**KIRKLEES METROPOLITAN COUNCIL
INVESTMENT & REGENERATION SERVICE**

DELEGATED DECISION TO DETERMINE PLANNING APPLICATIONS

Reference No: 2019/60/91141/W

Description: Outline application for erection of one detached dwelling

STREET ELEVATION FROM
NEW HEY ROAD

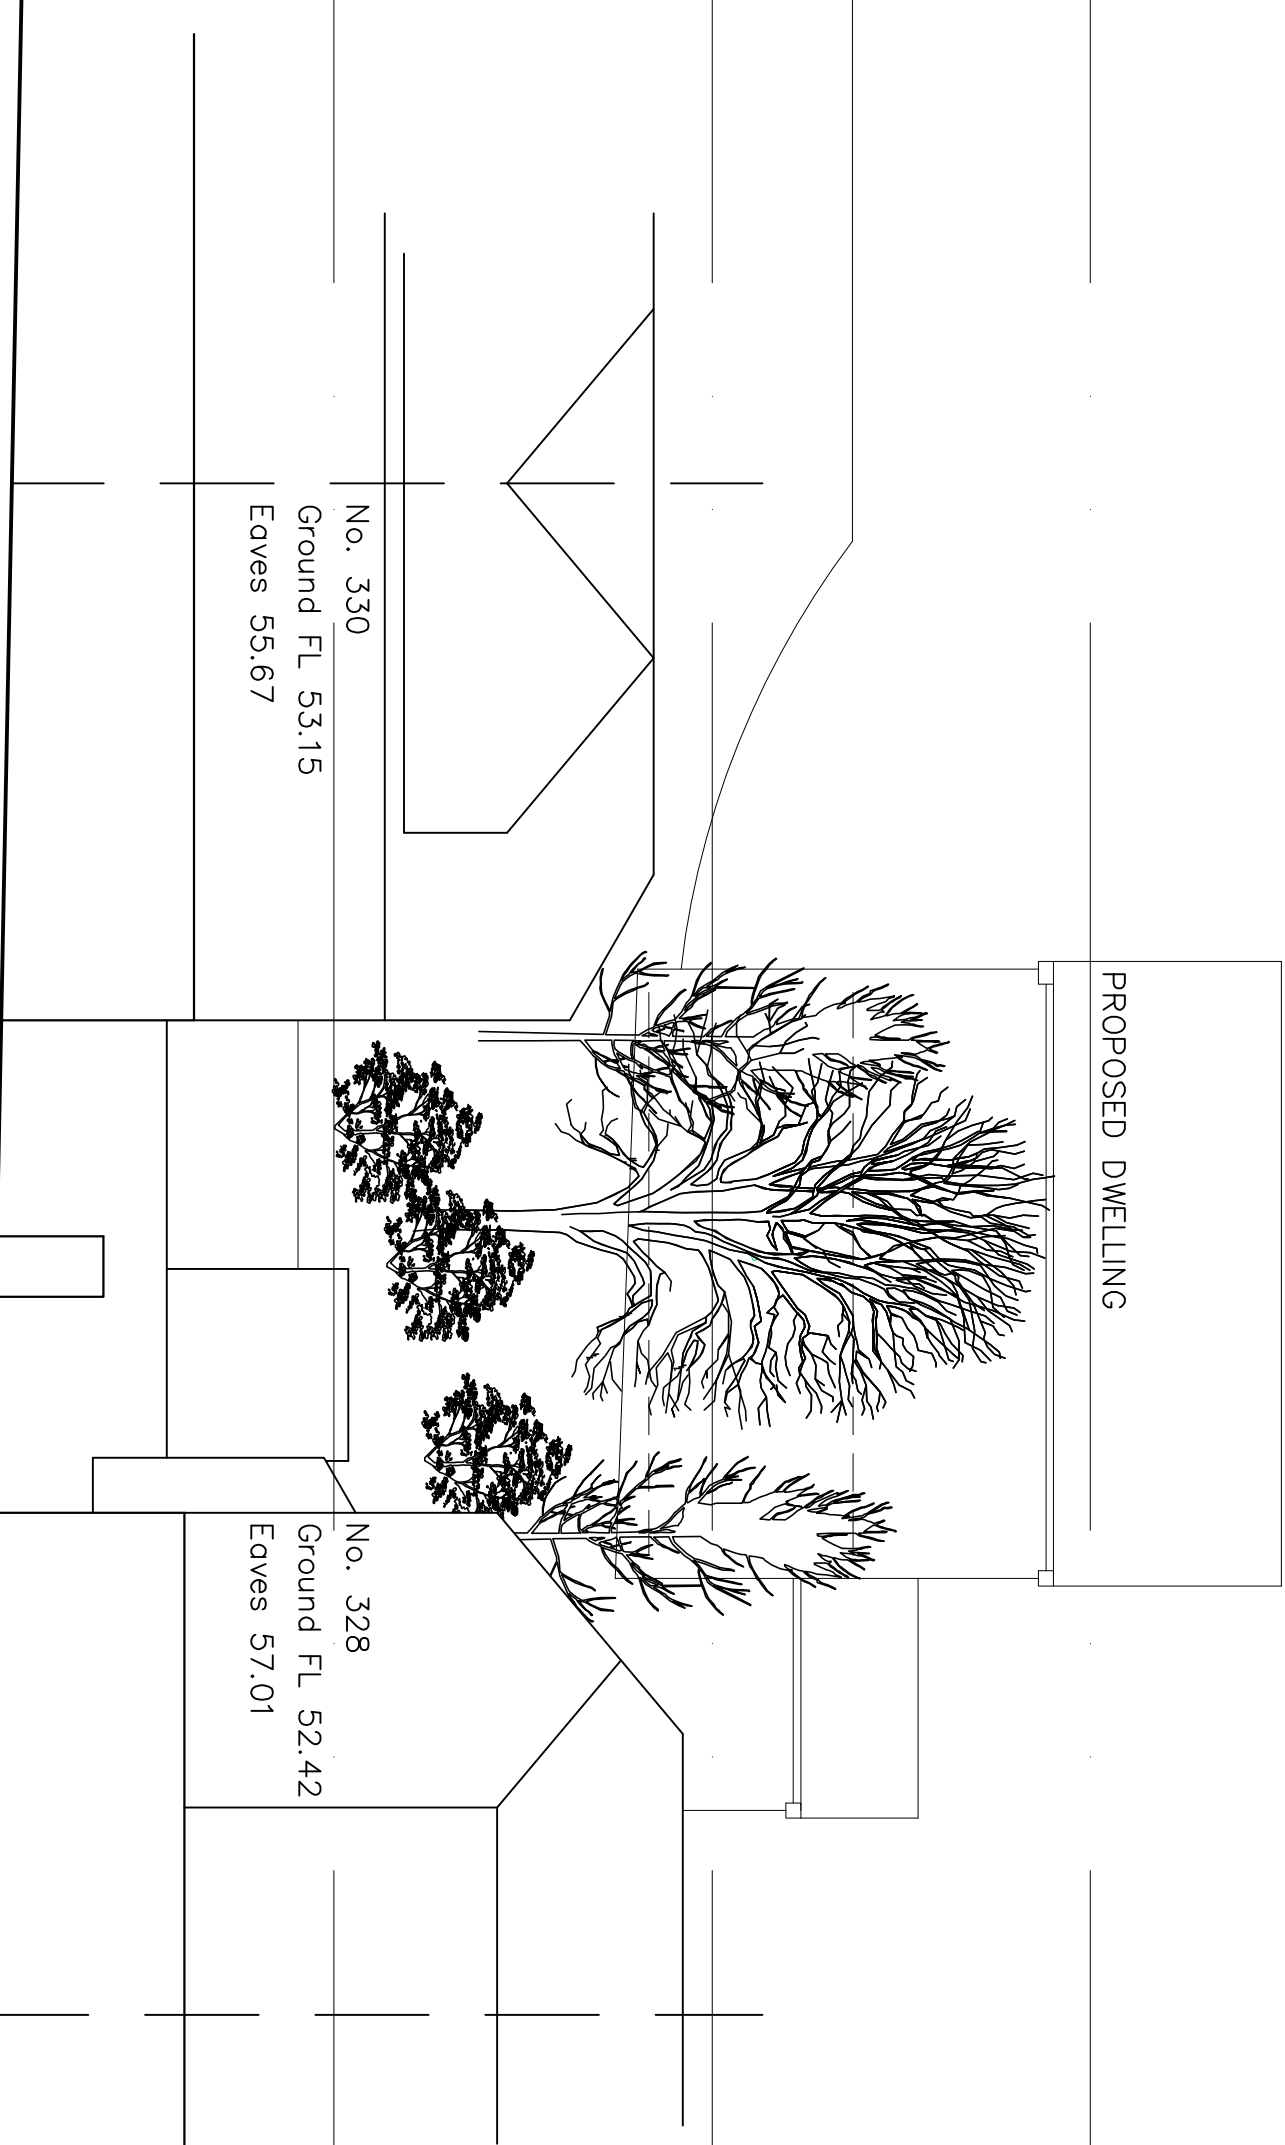
The indicative street scene elevation shows a dwelling that would be sited higher than those along New Hey Road, due to the raising land levels. While this height causes some concern on the current indicative plans, it is acknowledged that the dwelling would be set back from the frontage of these dwellings by 25 metres. Furthermore, the indicative mass itself is not undue. This set back would reduce the impact of the new dwelling on the street scene and the building would also be screened by the existing trees which are stipulated to be retained. Therefore, at this time and based on indicative plans, officers hold no substantive concerns of the siting and its impact on New Hey Road.

SITE PLAN

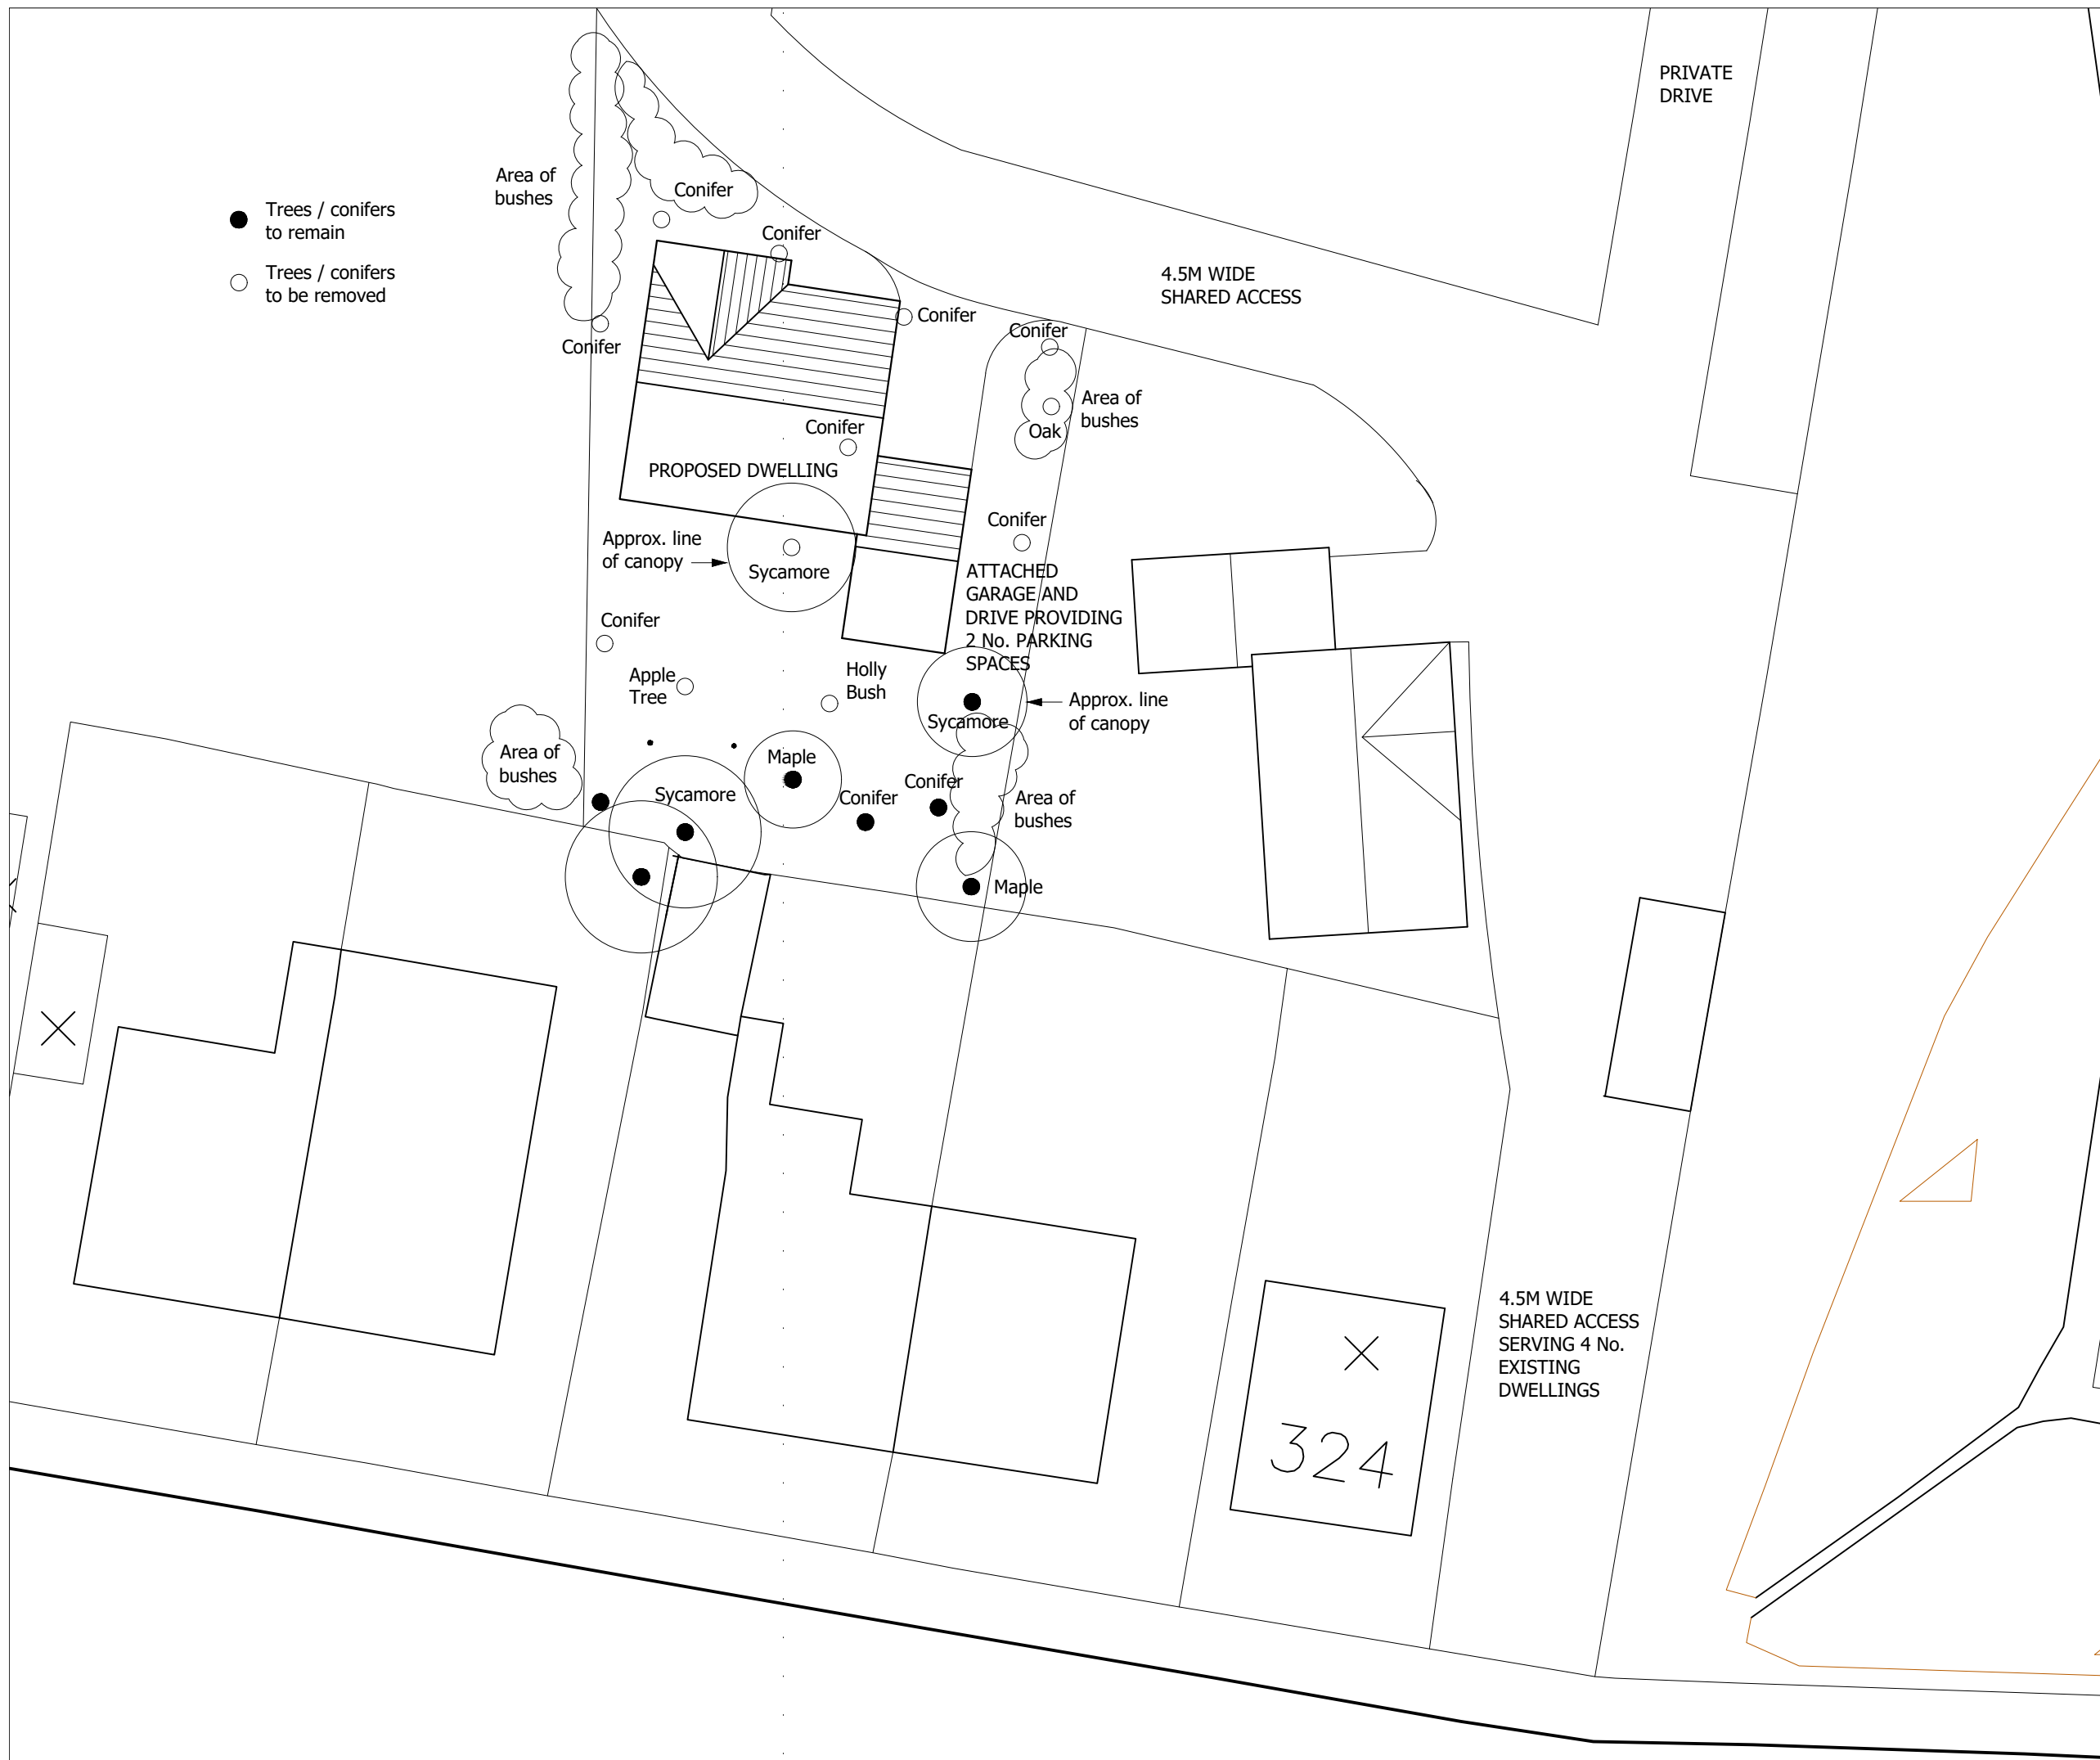
- The site plan has no north arrow.
- The location and site plans are incorrect and do not show the neighbouring dwelling's correct alignment or a rear extension on the adjacent no.330.

- The trees shown on plan are not correspond to those on site.
- The ordinance survey is out of date with no license reference and is presumably being reused from previous applications.

- The removal of trees and vegetation will harm local ecology.
- The amended layout plan, intended to show the neighbouring dwellings as extended and the orientation of adjacent dwellings, remains incorrect.

- The site plan has no north arrow.
- The location and site plans are incorrect and do not show the neighbouring dwelling's correct alignment or a rear extension on the adjacent no.330.
- The amended layout plan, intended to show the neighbouring dwellings as extended and the orientation of adjacent dwellings, remains incorrect.

- The trees shown on plan are not correspond to those on site.
- The removal of trees and vegetation will harm local ecology.

Reason: A north arrow is not a lawful requirement. Officers concurred that the initially submitted plans were not accurate, which led to the amended plans being provided and re-advertised. On review of the amended plans, aerial photos and site photos officer are satisfied that they are suitably accurate to assess the proposal.

Reason: The trees on site have been assessed as not being worthy of TPO status. Furthermore the layout, and the direct impact on the trees in question, cannot be fully understood. Therefore it would not be deemed reasonable to require a fully and formal tree survey at this time.
